CITY OF ALBUQUERQUE

**Re: Murphy Express, San Mateo Blvd. and Zuni Rd.
Grading and Drainage Plan
Engineer's Stamp Date 7-29-13 (L18/D079)**

Based upon the information provided in your submittal received 7-30-13, the grading and Drainage Plan is approved for Building Permit.

GRADING AND DRAINAGE PLAN

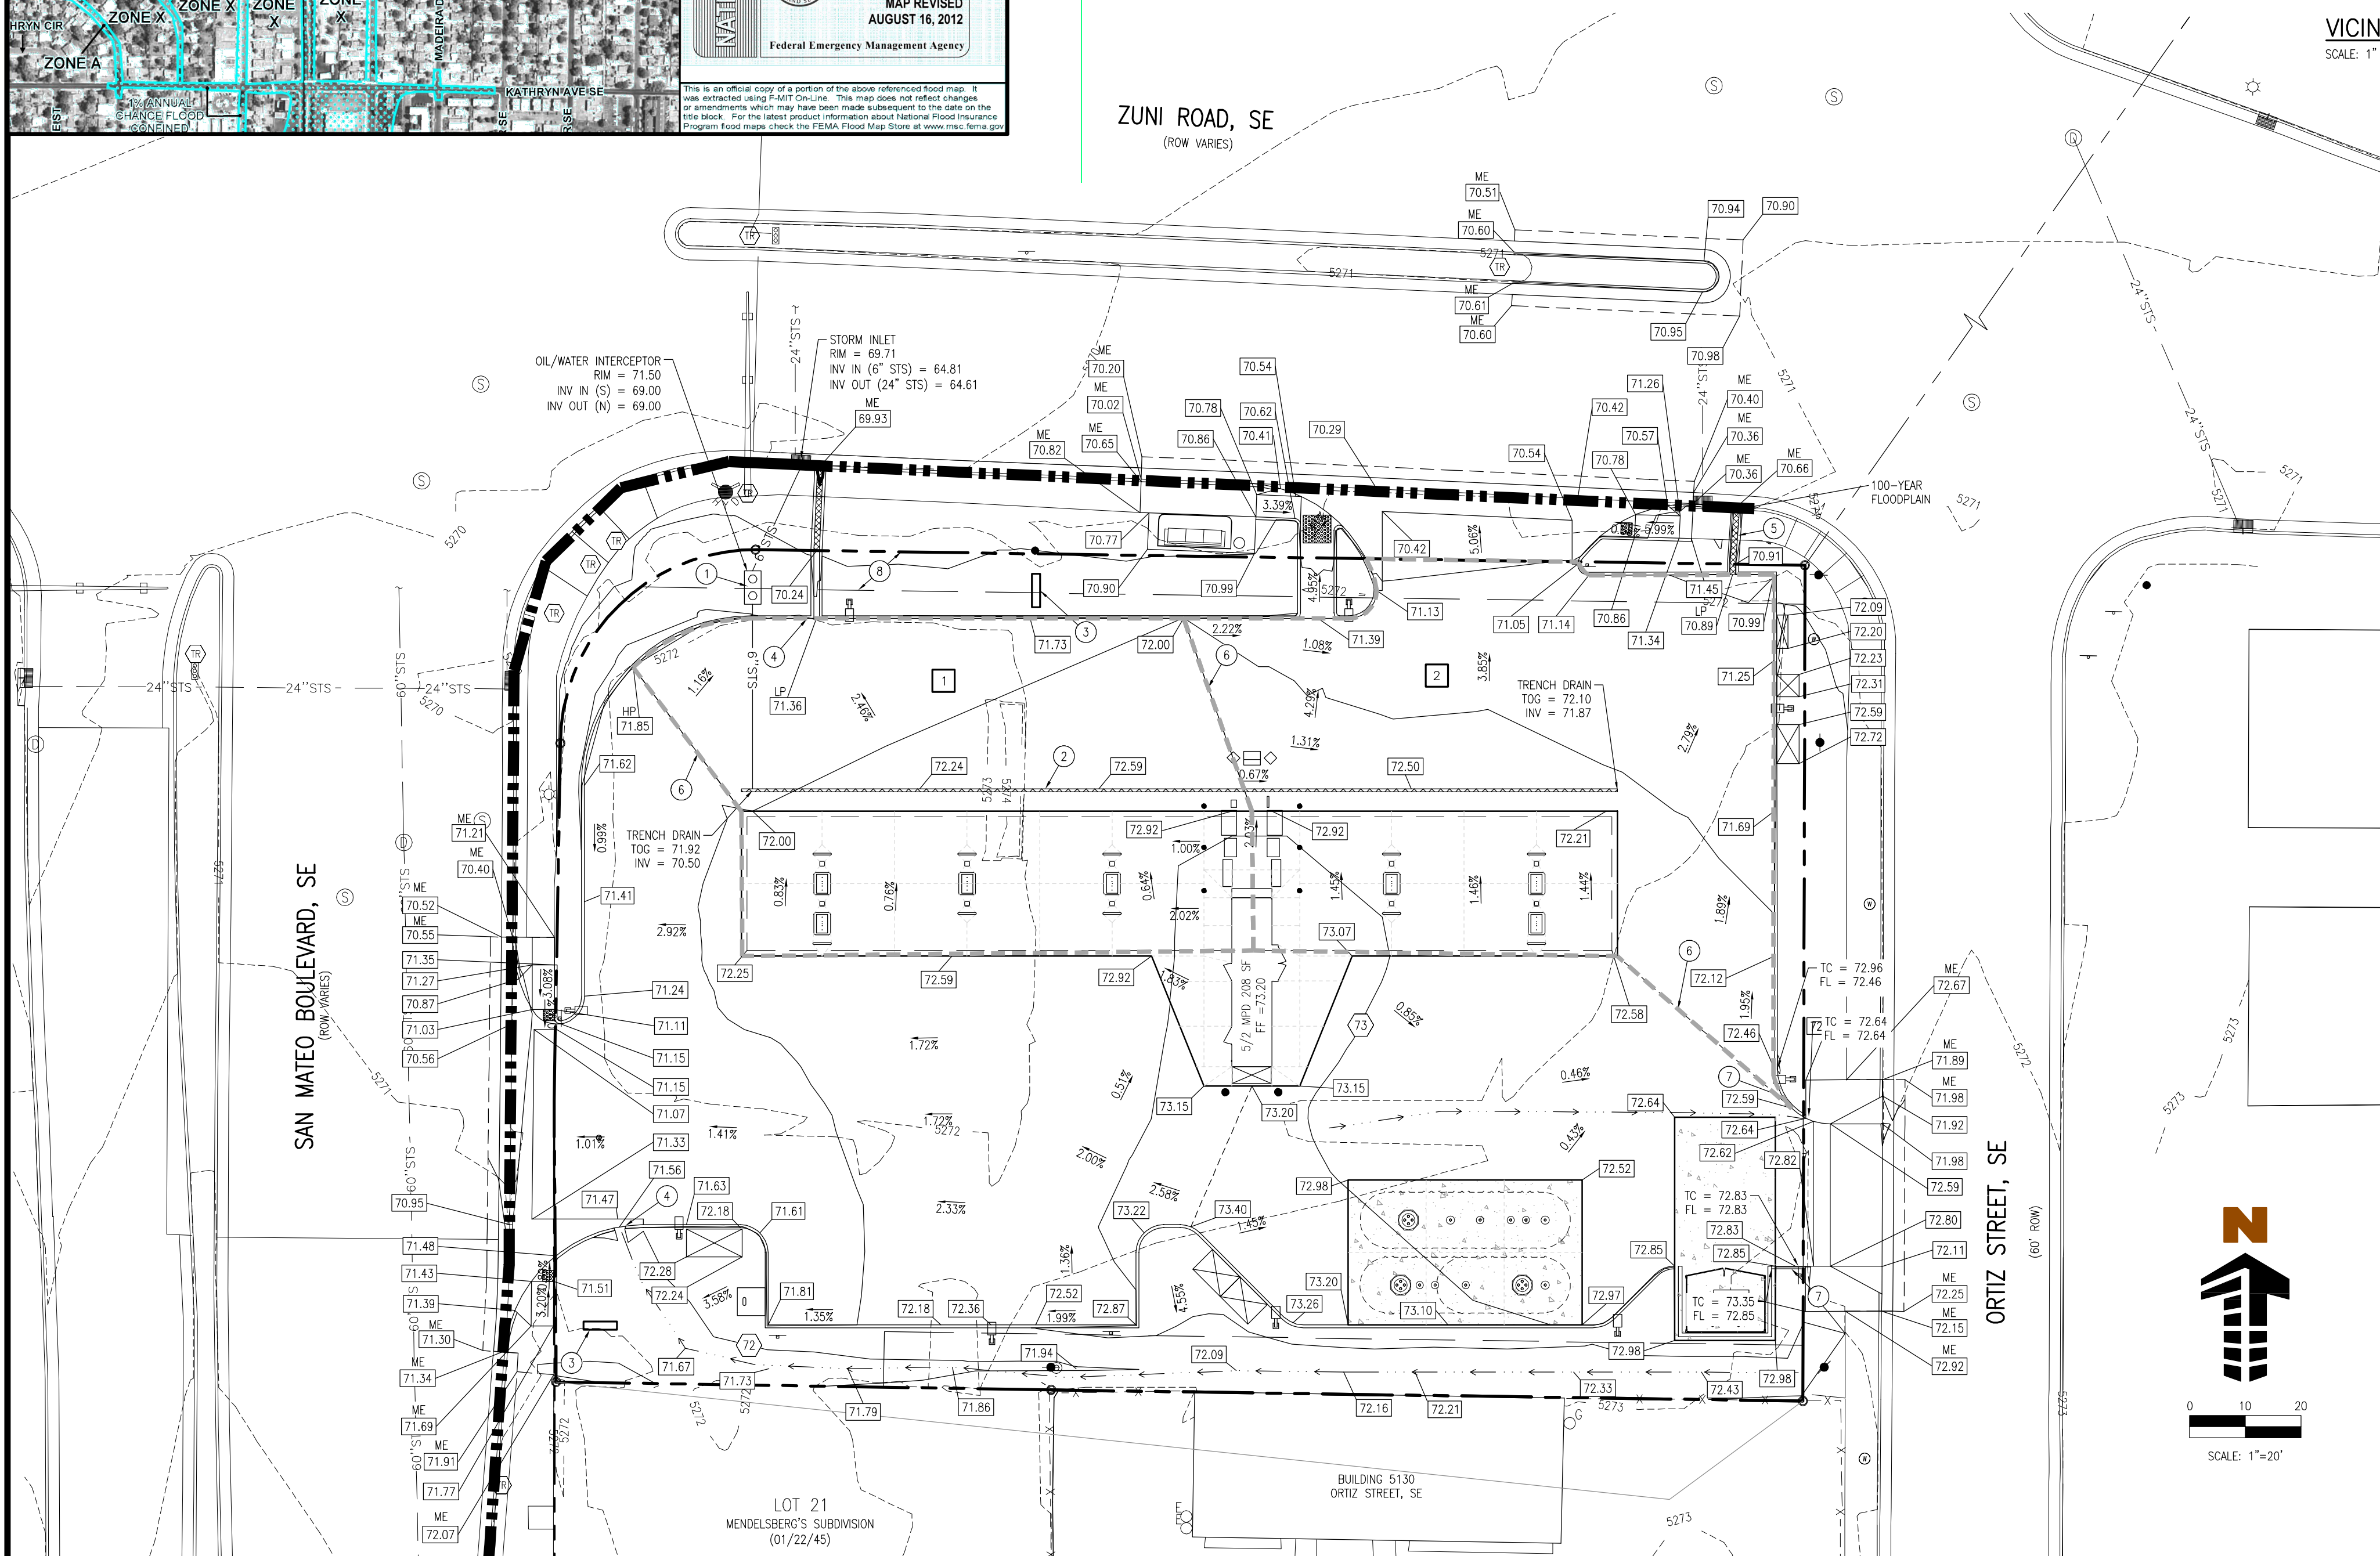
- Provide adequate as-built elevations around the pumping and near pumping areas to ensure drainage of the pumping areas to the trench drain and other areas away from the pumping areas.
- Include additional as-built elevations along the property line to assure proper drainage on-site and within the right-of-way.
